**MODIFICATION REQUEST:**  
**Royal Rehabilitation Centre Sydney**  
**Health Facility**  
**600-640 Victoria Road, Ryde**  
**(MP 08\_0054 MOD 4)**

Director-General's  
Environmental Assessment Report  
Section 75W of the  
*Environmental Planning and Assessment Act 1979*

August 2012

DRAWING
SITE PLAN

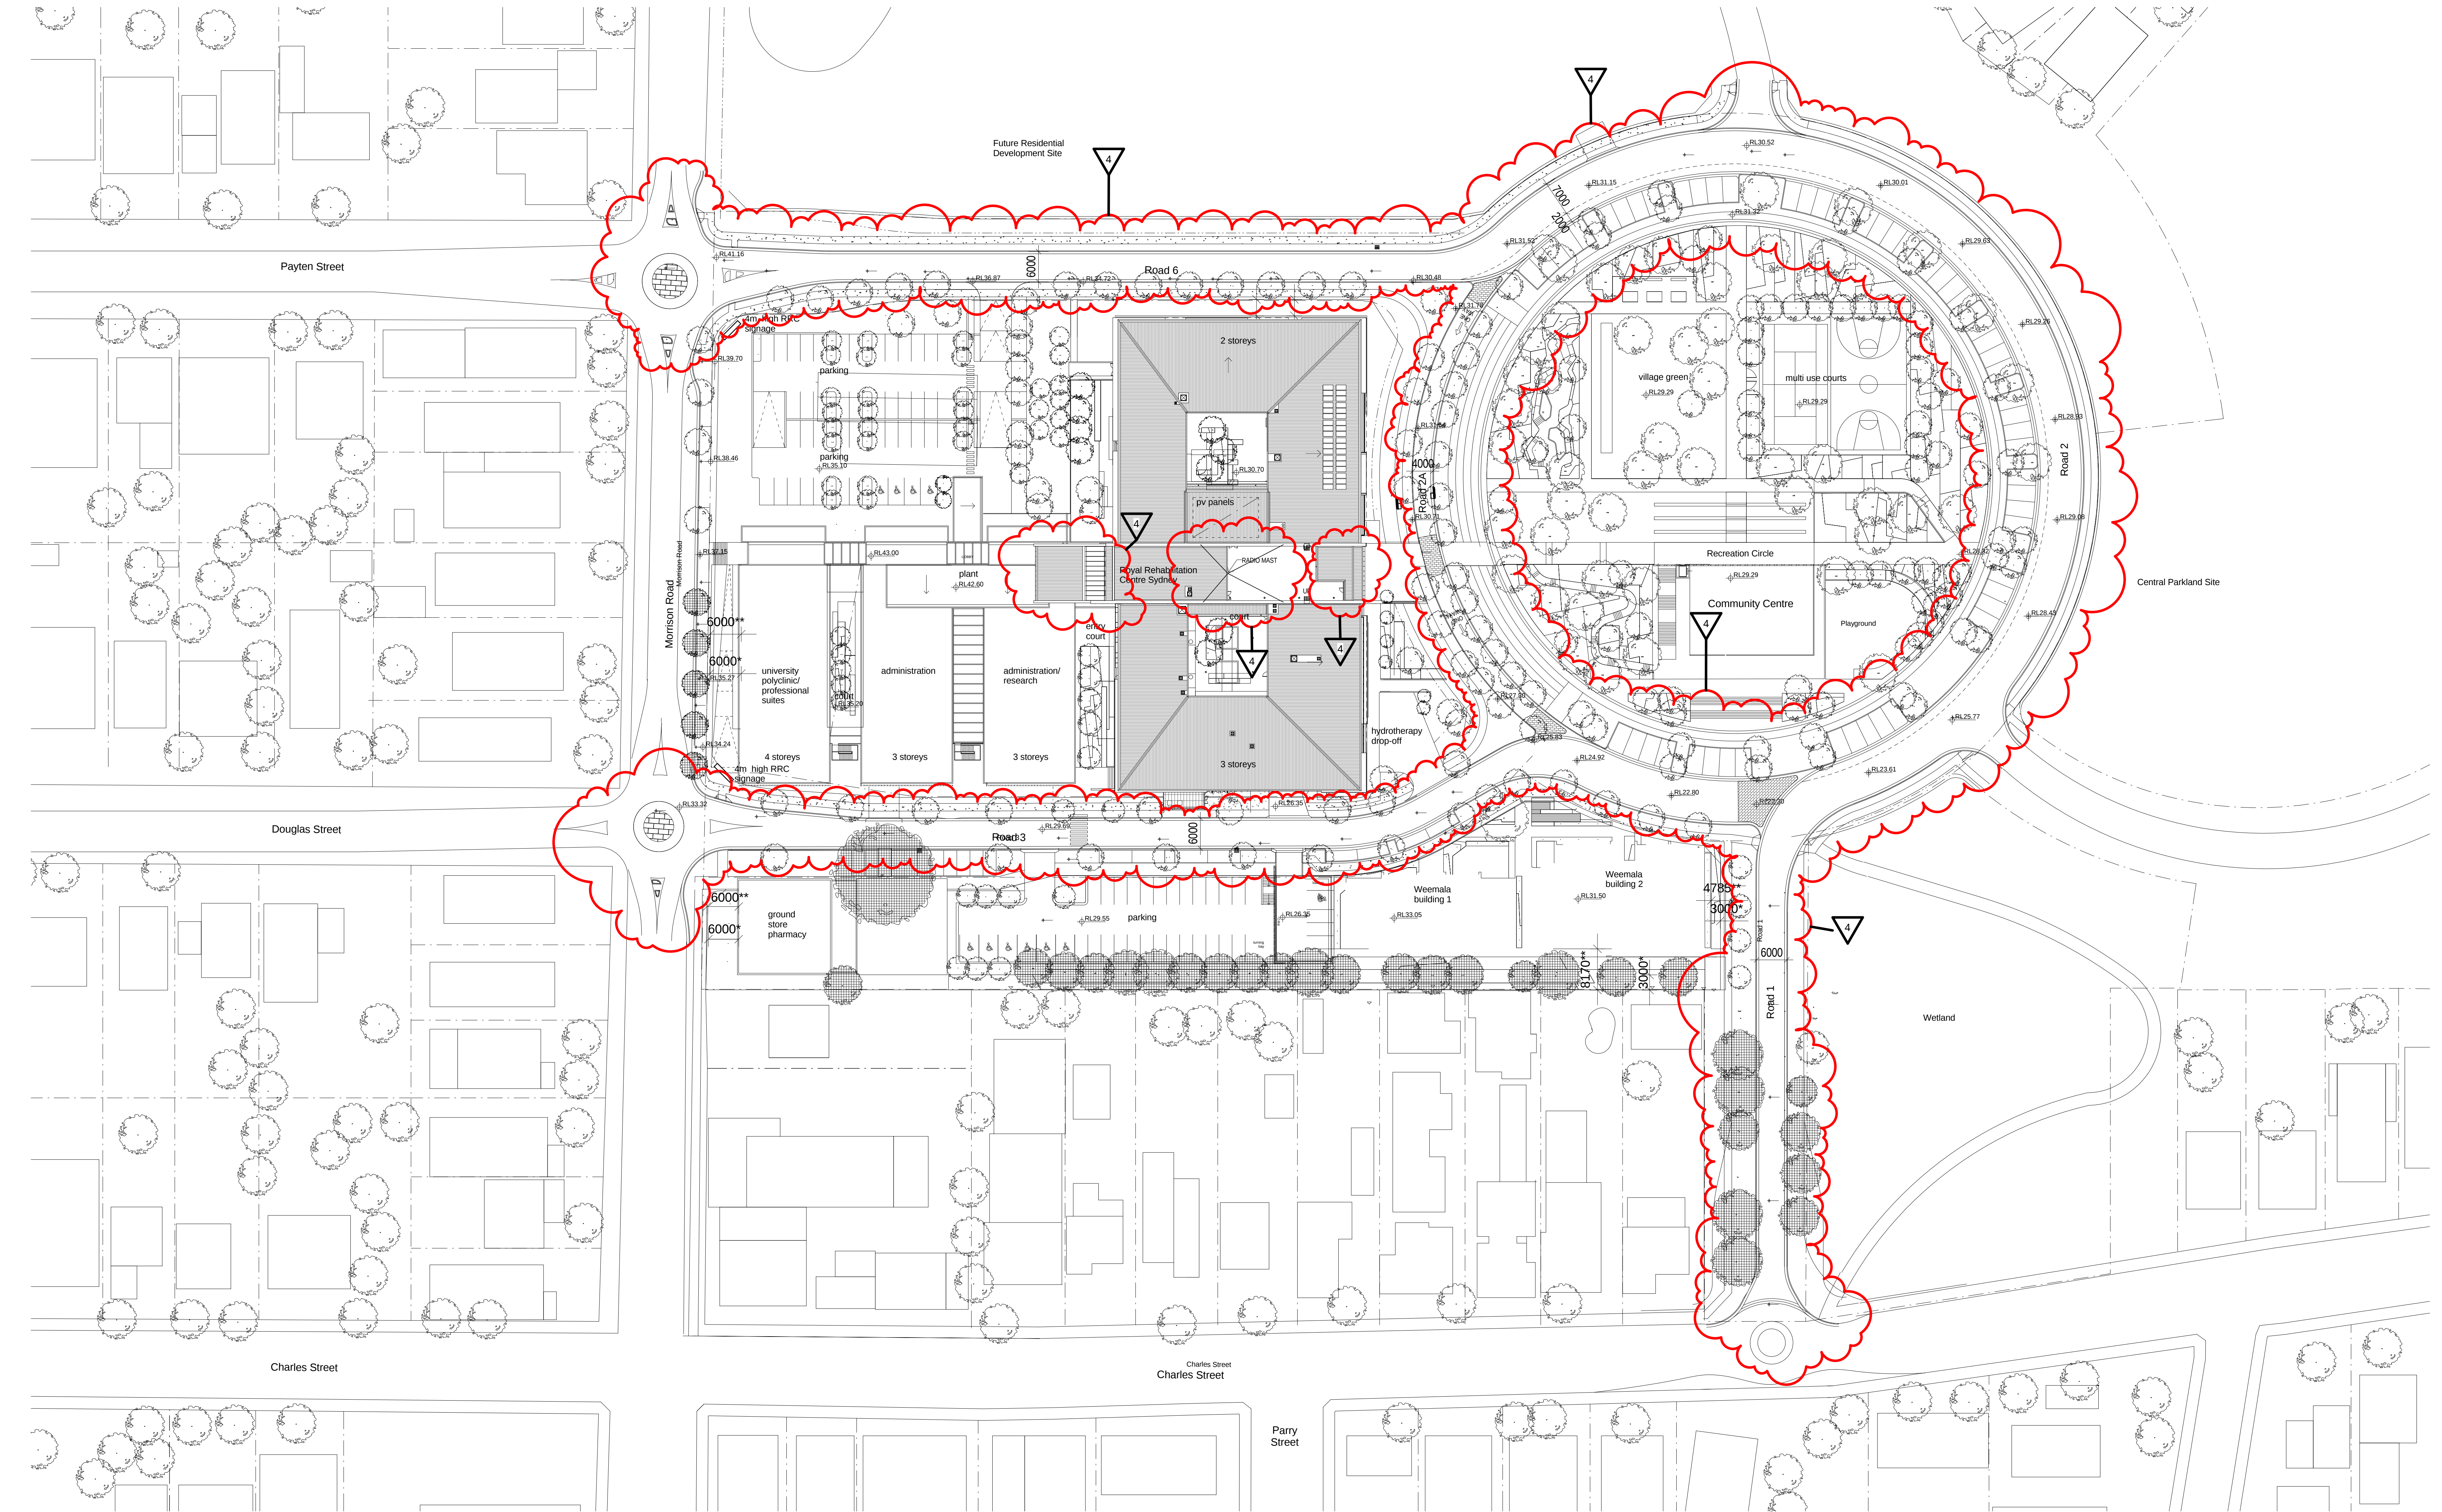
The proposed modification includes reduced road widths of Roads 1, 3 and 6 from 7 m to 6 m and the introduction of a new one-way road section along Road 2 (labelled Road 2a) including a reduced road width of Road 2a from 7 m to 4 m. The remainder of Road 2 is not proposed to be modified, and will remain at a width of 7 m with a 2m buffer behind 90 degree angled parking around recreation circle (see Figure 4 in section 2 of this report).

Council's submission recommended that consideration be given to the ability of the Road 1 (as modified) to accommodate different vehicle types (including waste collection vehicles, removalist vans, emergency vehicles, and other service vehicles) and the volume of traffic generated by the Health Facility, the shared use of recreation facilities, use of central parkland and wetland areas and the residential development on the RRSC site.

Council's submission also identified that, with the introduction of a proposed new one-way road section (Road 2a), the potential arises for drivers who are heading north to take a wrong left turn and end up on Morrison Road via Road 3 (instead of travelling around the eastern side of the Recreation Circle). Notwithstanding, council identified that the proposed new one-way road section (Road 2a) is in the interest of protecting patients and other pedestrians using the site, and identified that the proposed change would make the precinct more 'pedestrian friendly'.

The department supports the amendments as the proposed reduced carriage widths would continue to provide for single lane traffic in each direction and would be consistent with the approved 6 m road width of the adjacent Roads 4 and 5 (as

modified by MOD 3) associated with the residential component of the RRCS site. Additionally, the turning paths of the large vehicles likely to enter the site would still be accommodated. The other changes to the street finish pattern of the Health Facility roads (as modified) will direct vehicles heading north or south to travel around the eastern side of the Recreation circle, and the proposed one-way section of Road 2 (labelled as Road 2a) will improve pedestrian safety and connectivity.

SITE ELEVATIONS

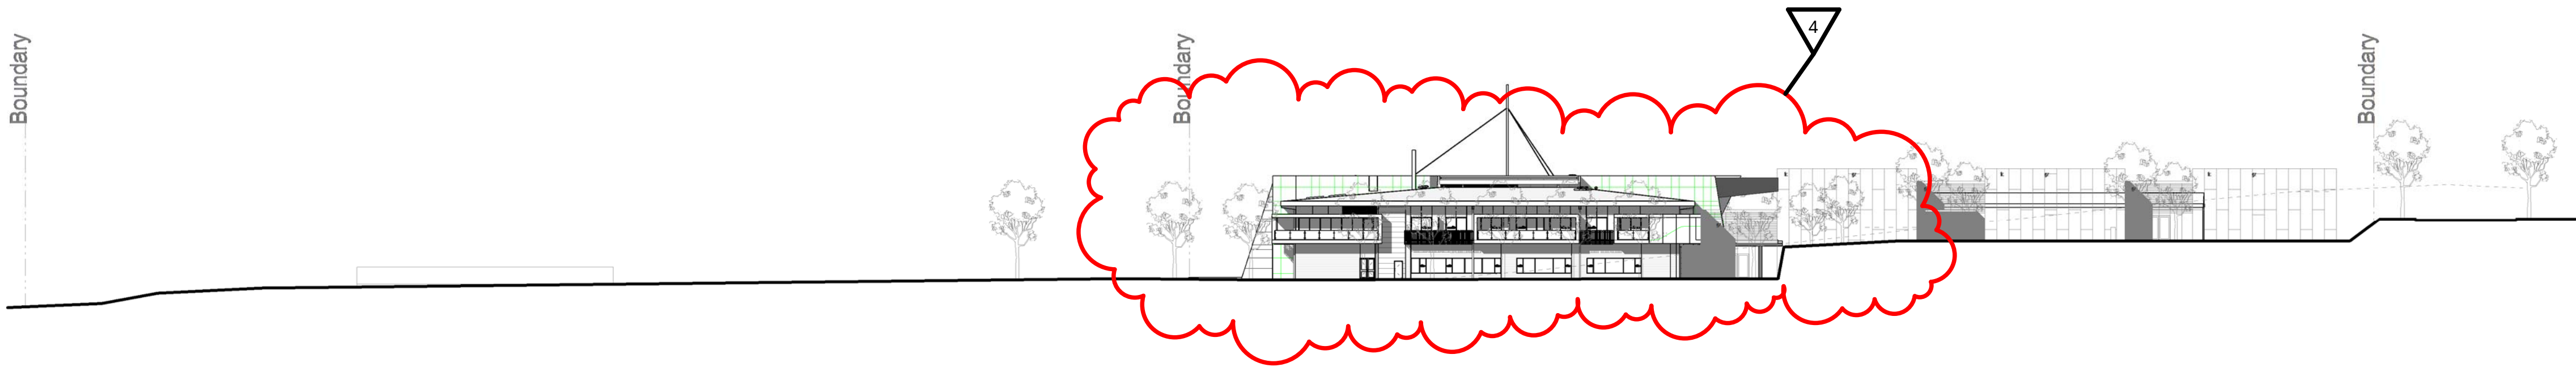
In addition, the proposed modification includes additional service infrastructure, (which is reflected in both stage 3 and stage 4) including a radio mast and boiler flue. A porte cochere is also proposed to the west of the Health Facility building, which is to be removed in stage 4 to accommodate construction of the Finger Buildings. The proposed stage 3 and stage 4 eastern elevations of the Health Facility Building, including the proposed porte cochere, radio mast and boiler flue are identified in Figures 9 and 10.

The approved concept plan (MP05\_0001) established a building height limit of 5 levels or maximum RL of 51 over the site of the Health Facility. The minor external design revisions will not result in any additional building height from the approved development, with the highest point of the building being the lift overrun at RL 43.6. Additionally, the proposed boiler flue, which extends 3 m above the roof line (RL 45.75), will also comply with the concept plan height limit. However, the proposed radio mast at RL 53.4 will exceed the concept plan height limit by 2.4 m. The proponent has identified that the radio mast is required to have a direct line of sight to Royal North Shore Hospital.

Under Ryde Local Environmental Plan 2005, building height is defined as the vertical distance between ground level (existing) and the highest point of the building, including plant and lift overruns, but excluding communication devices, antennae, satellite dishes, masts, flagpoles, chimneys, flues and the like. Accordingly, the radio mast (and the boiler flue) does not contribute to the building height of the Health

Facility Building, and therefore the proposal (as modified) is considered to comply with the concept plan. The department does not consider that the radio mast and boiler flue will result in any additional building bulk or additional significant overshadowing.

Accordingly the department considers that the proposed design revisions, additional service infrastructure, and revised plans incorporating stage 3 and stage 4 of the Health Facility Building to be acceptable.
